Recommendation Report for Planning Permission for Works or Extension to a Dwelling

REF NO: BR/118/22/HH

LOCATION: 26 Westway
Bognor Regis
PO22 8BZ

PROPOSAL: Erection of side/rear extension following demolition of existing side garage and rear extension and removal of chimney.

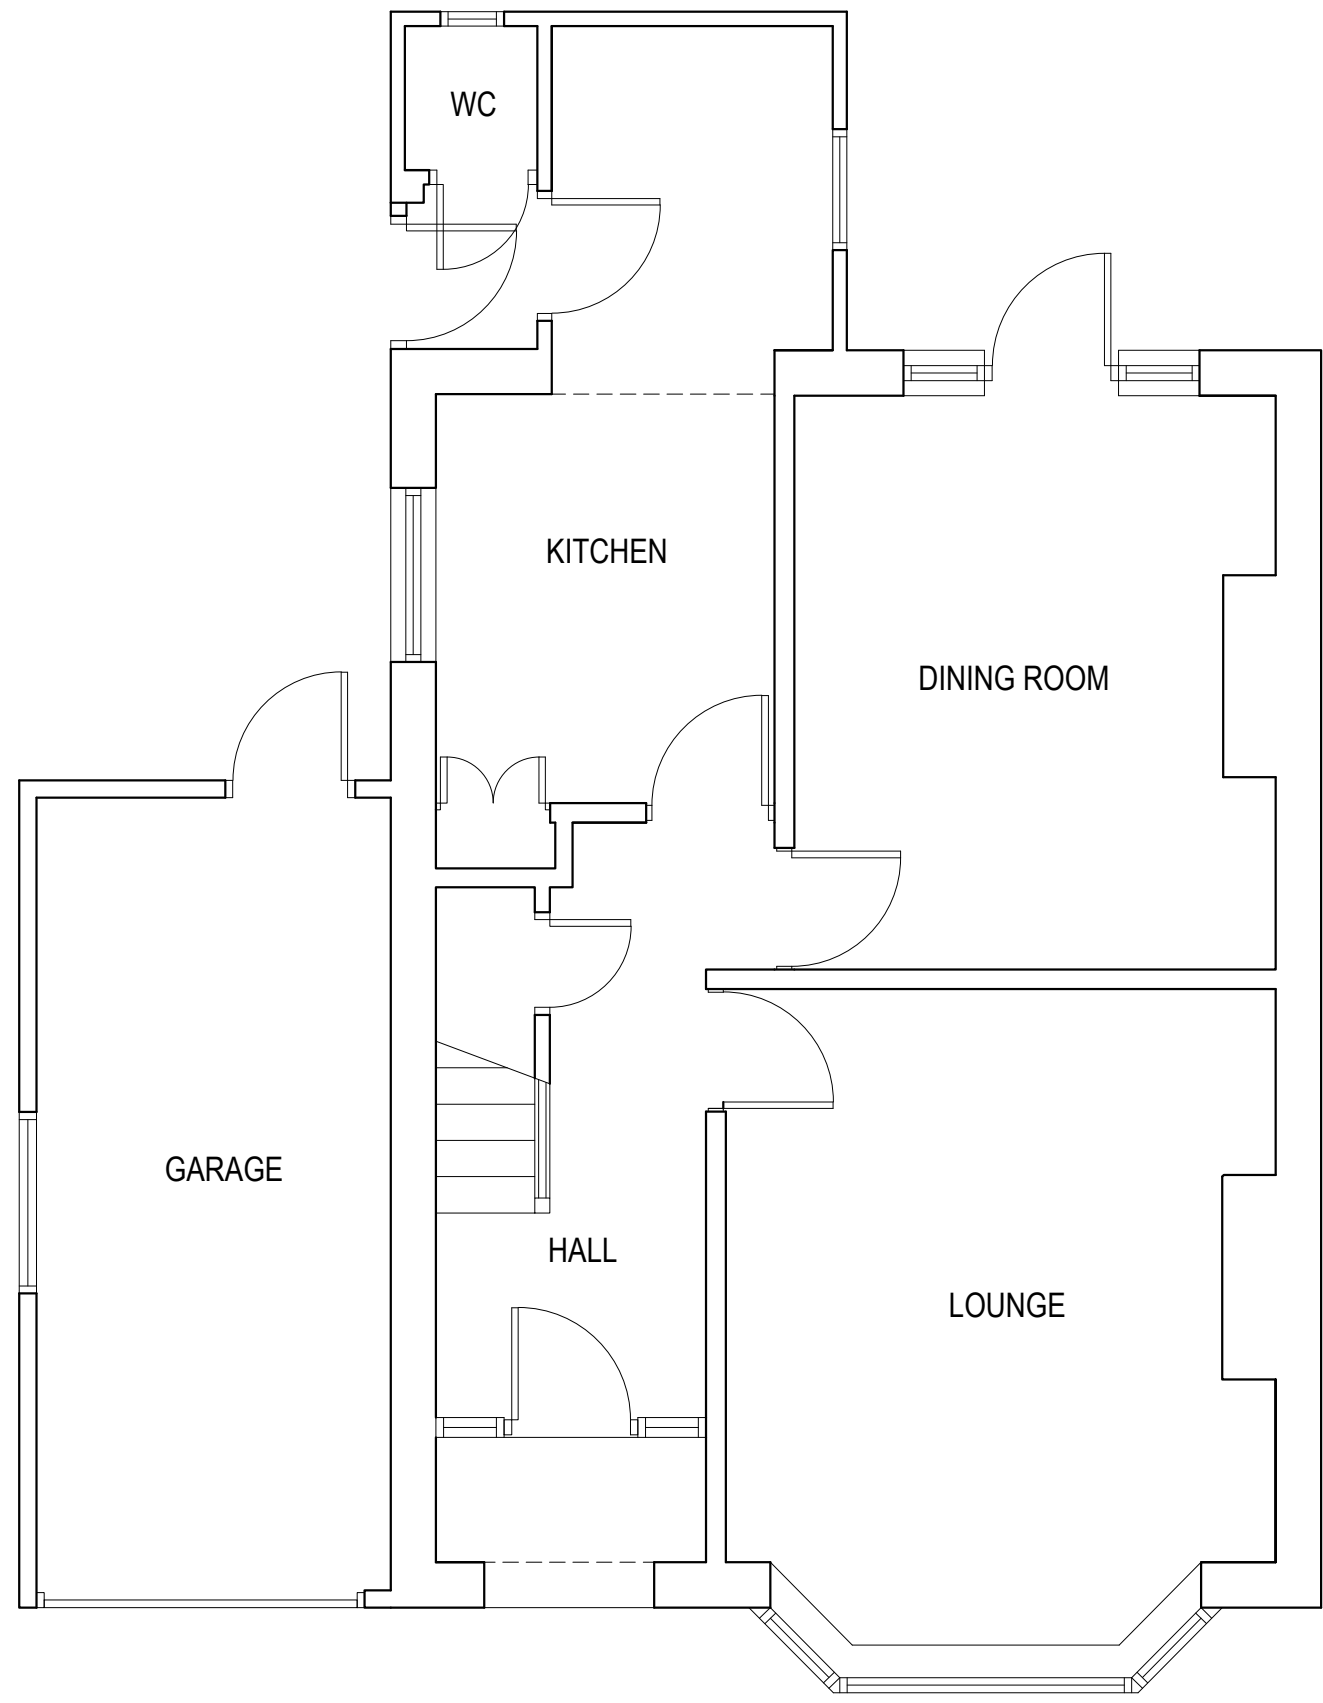
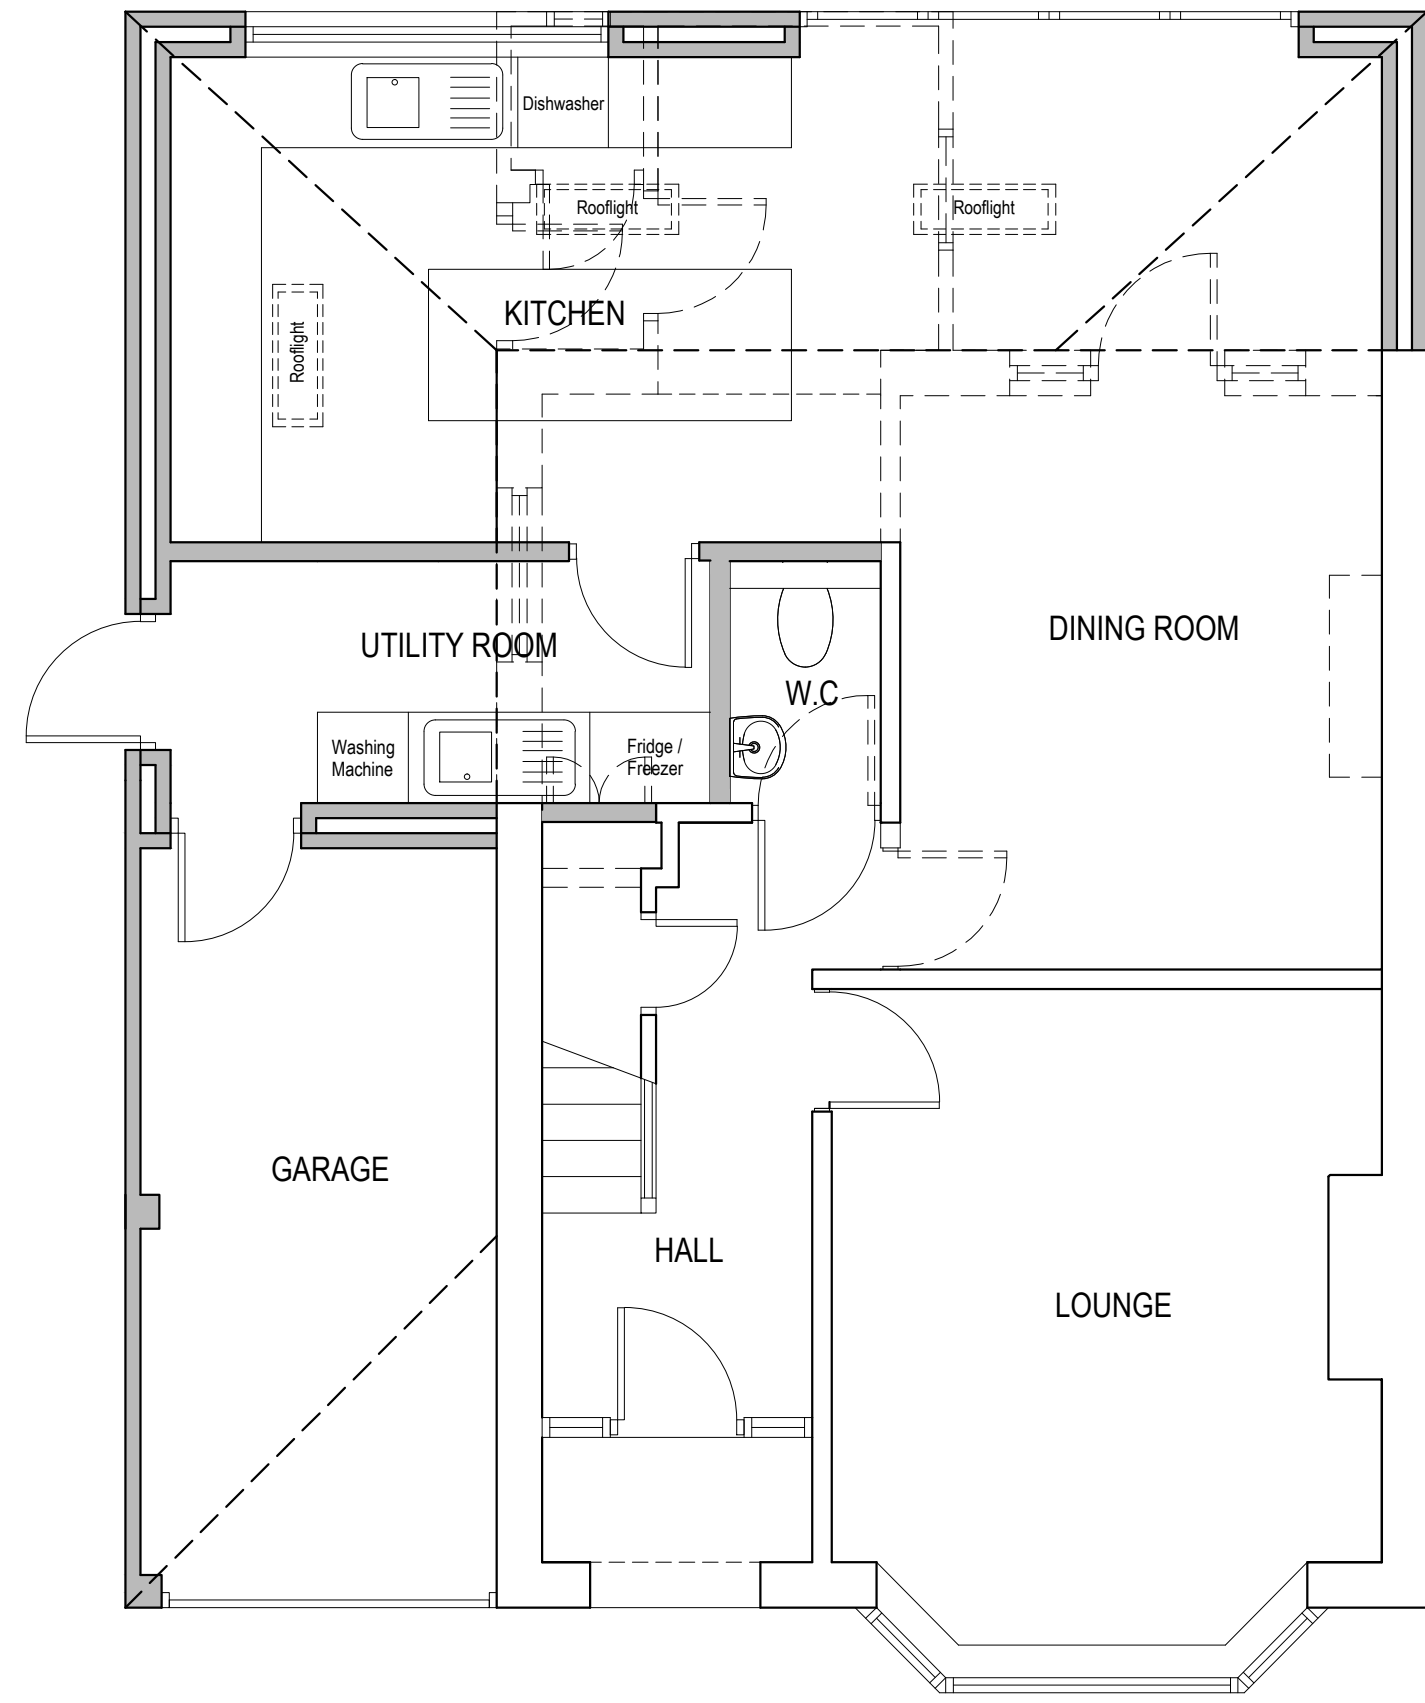
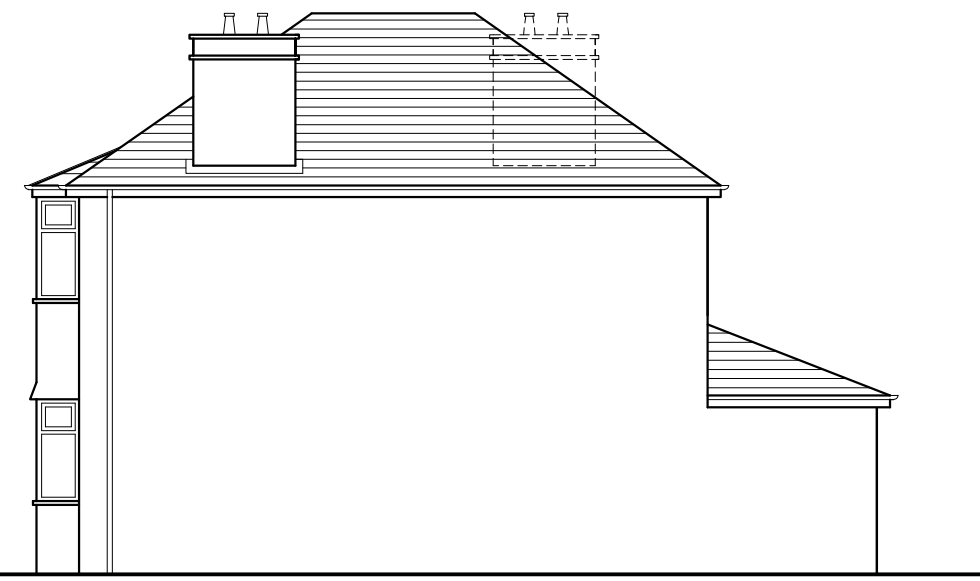
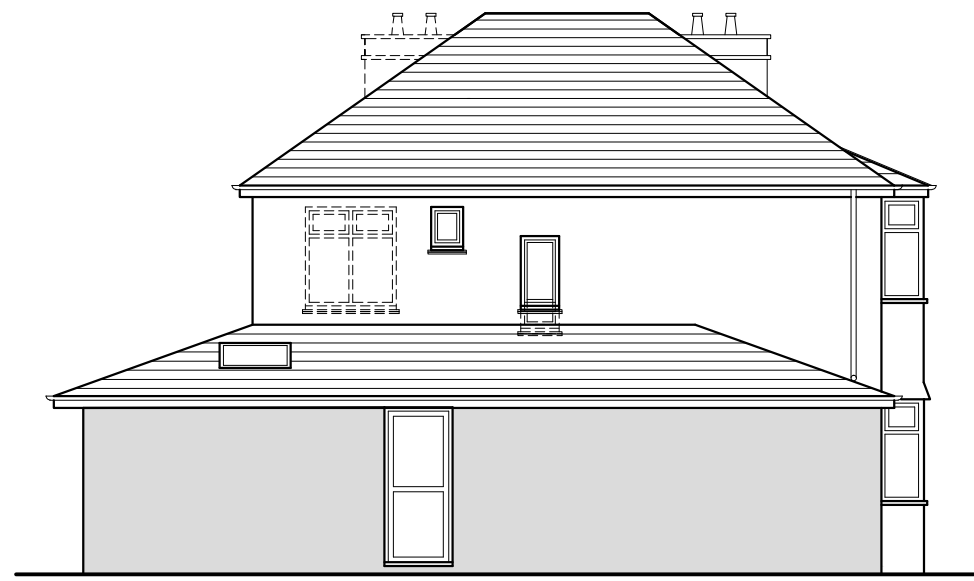
The 'wrap around' extension will replace two existing structures: a garage to the side and small extension to the rear and will cover the full width of both elevations. It will include a new garage, of similar scale and footprint to the existing, and kitchen and utility room which will wrap around the rear. It is a modest development, and an appropriate replacement, retaining a similar projection to the existing side and rear structures of approximately 2.5m to the side, and 2.2m to the rear. It will have a hipped roof, which although differing to the gable roof of the existing extensions, will integrate more sympathetically with the hipped roof of the host dwelling. The proposal will have minimal impact on the visual appearance of the property and will remain in keeping with its character, posing no risk of harm to visual amenity.

Being to the side of the property, the extension will be visible from the street scene to the front. This will have some impact on the composition and appearance of the street. However, given that the proposal is replacing an existing garage with another garage of similar scale, location and design, this impact on the composition of the street will be very minimal. The proposal will not significantly alter the appearance of the property, retaining a similar style to the existing, and will remain in keeping with the character of the dwelling, and the locality.

The proposal appears subservient to the design of the dwelling and is well integrated. It will use materials primarily matching the existing, ensuring minimal intrusion on visual amenity. The extension is appropriate in terms of scale and massing and will not unduly obtrude or dominate the host dwelling. It is in keeping with the character of the property, and the locality, and is acceptable.

The removal of the chimney is acceptable and will have minimal harm on the visual appearance and character of the property. Being located to the rear, this alteration will have little impact on the composition and appearance of the street and will have no impact on the character of the area.

The proposal will be single storey and have a hipped roof at approximately 3.3m high, and 2.35m at the eaves. This roof will include three rooflights, all of which will be flush and result in no harm to residential amenity. The extension will retain 5.9m to the north boundary, 1.1m to the east, 14.1m to the south and 0.87m to the west. These distances are in accord with D DM4 and will not result in any adverse

overbearing or overshadowing of the neighbouring properties located to either side of the dwelling. The distances are also benefitted by the proposal not projecting further south than the existing rear elevations of both neighbouring properties to the sides and remaining compliant with the 45- and 60-degree rules set by the Arun Design Guide. As such, there will be little resulting harm on their residential amenity.

In addition to the rooflights, the proposal will also see the installation of a door to the east elevation and set of doors and windows to the south elevation. It will also feature the removal of one set of windows to the east elevation and decrease in size of another on the same wall. These features and alterations will not result in any adverse overlooking of any neighbouring properties and are acceptable, posing no risk of harm to residential privacy or amenity.
